**Consultation Response from KC, Highways Development Management****2022/92468 Nomadic Pizza Ltd, 3 A, The Old Stone Yard, Near Bank, Shelley, Huddersfield, HD8 8LS****Change of use from general industrial/prep kitchen to restaurant and event space****Date Responded: 12/09/22****Responding Officer: J Turner****Responding Ref: K12-47/22**

This application seeks approval for the change of use from general industrial/prep kitchen to restaurant and event space at The Old Stone Yard, Near Bank, Shelley.

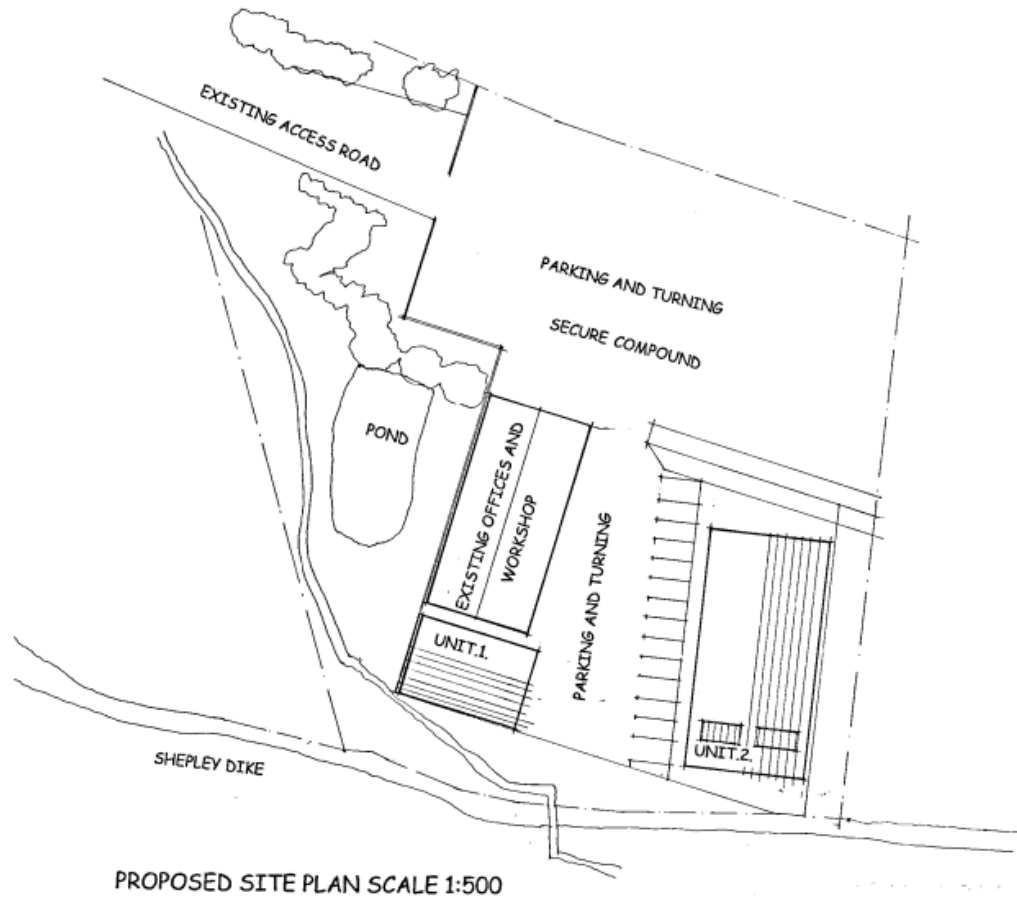
- Details on the maximum number of diners and maximum number of customers during an event.
- Information as to how any outdoor space is to be used.
- The eight off-street parking spaces marked on a plan and how they will be reserved for staff/customers of this unit only. Depending on the likely number of customers, this level of parking may have to be justified by providing statistical analysis of similar enterprises. As a guide, Kirklees' previous parking standards recommended one space per three staff and one space per 4m<sup>2</sup> of floor space.
- Bin storage and collection pads marked on a plan.
